Ann Machado - 467 Danforth Street - Permit #2013-02805

From: Ann Machado
To: adam@mastconstructioncorp.com
Date: 1/9/2014 9:45 AM
Subject: 467 Danforth Street - Permit #2013-02805

I have completed my zoning review and at this point I cannot sign off on the permit.

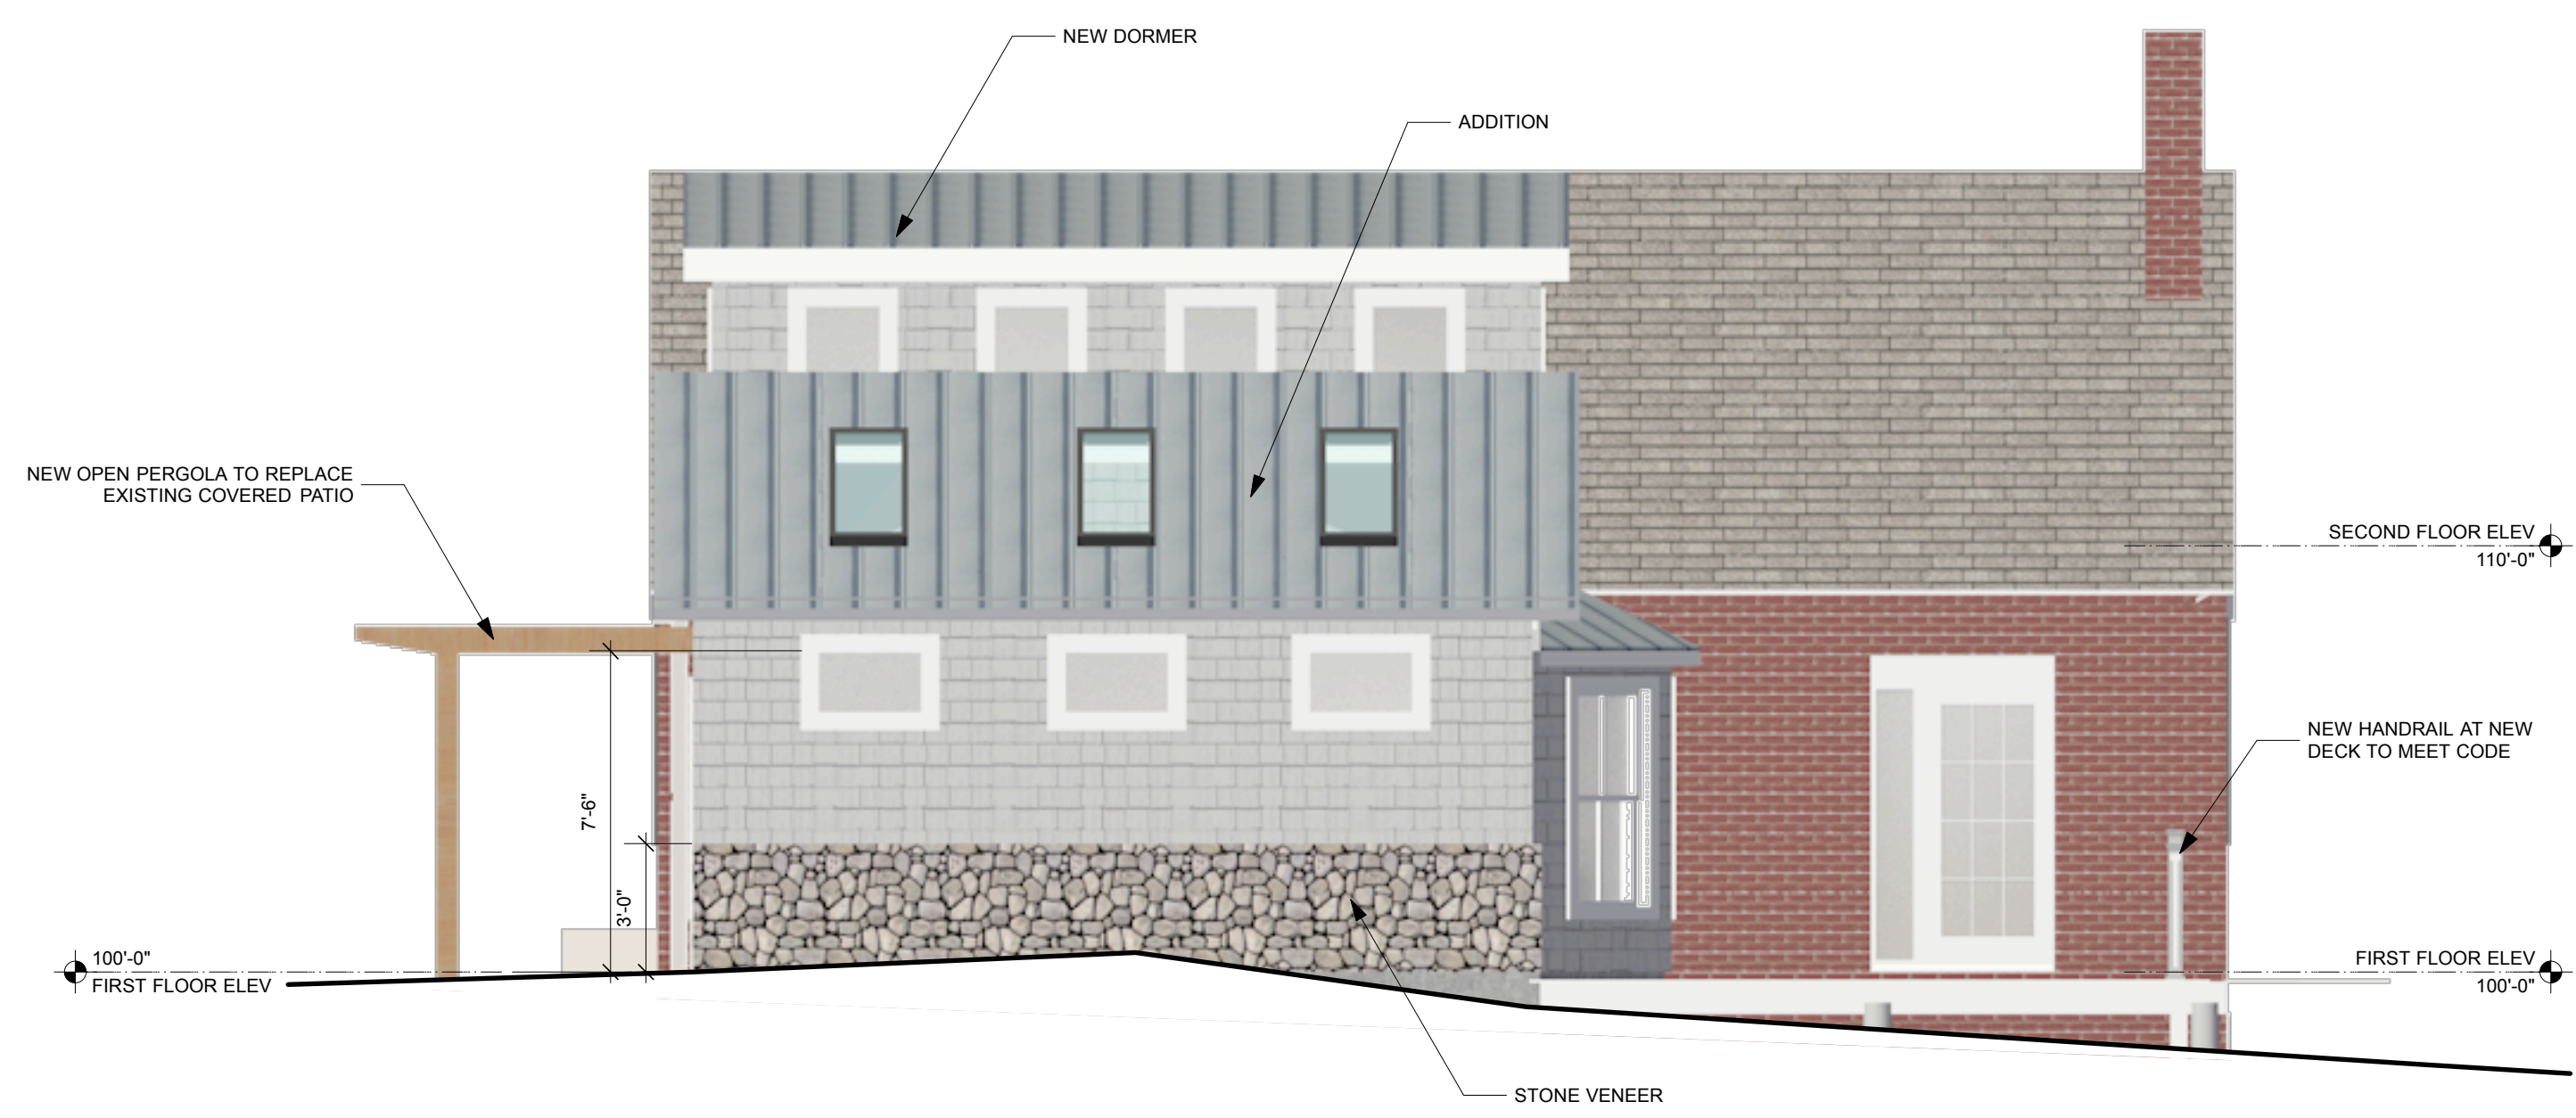
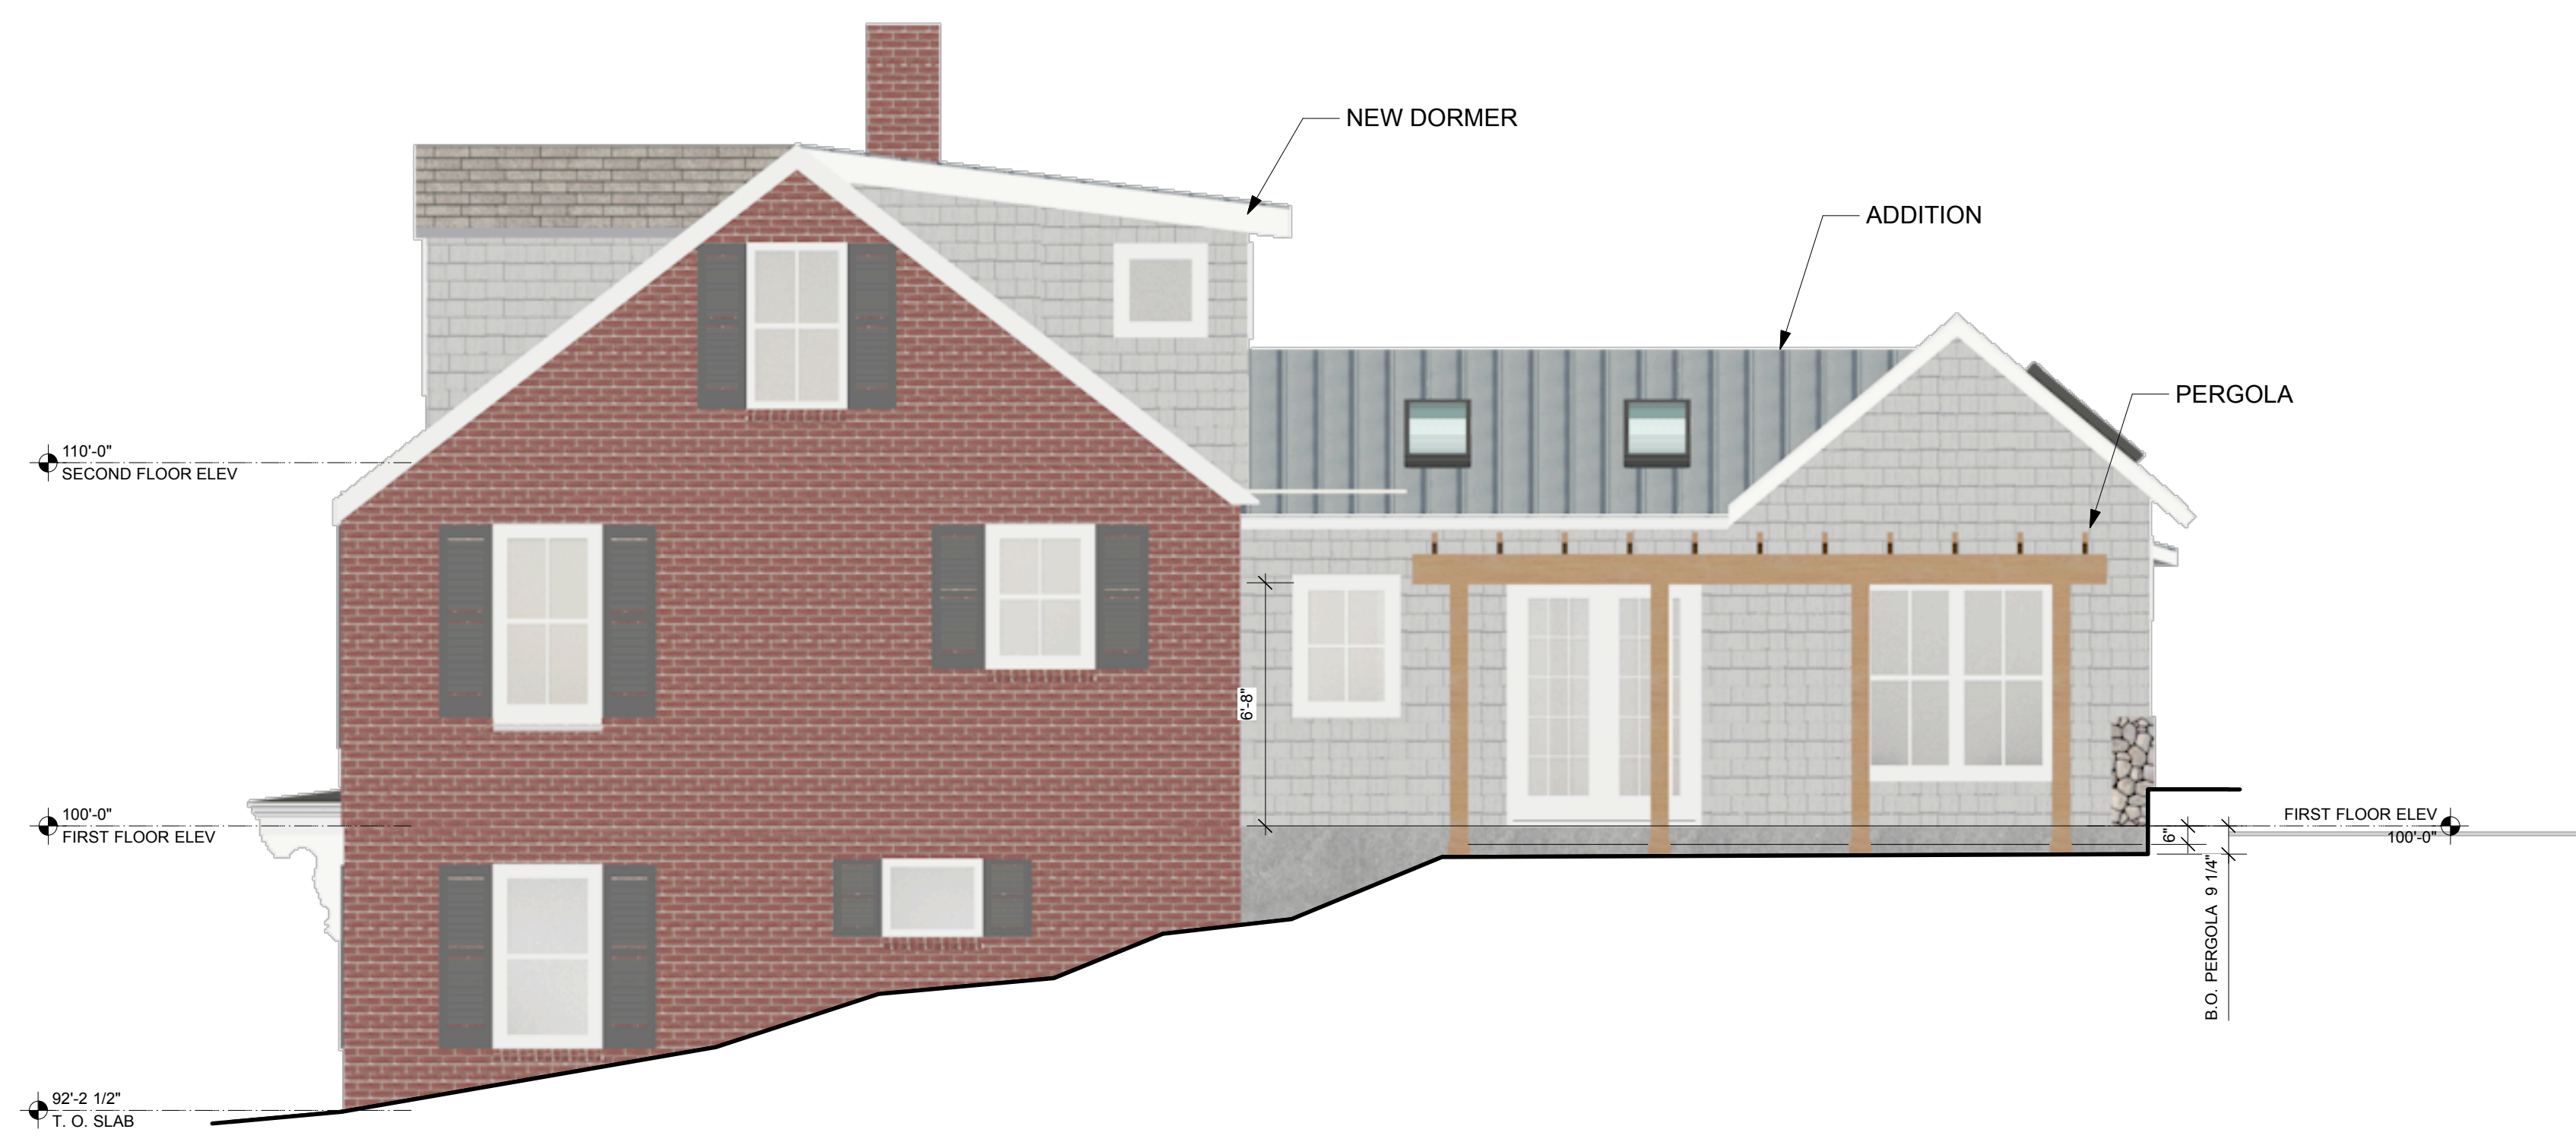
1. The plans that were submitted do not have a graphic or bar scale. With electronic plan review each plan needs a graphic scale so I can calibrate the measuring tool.
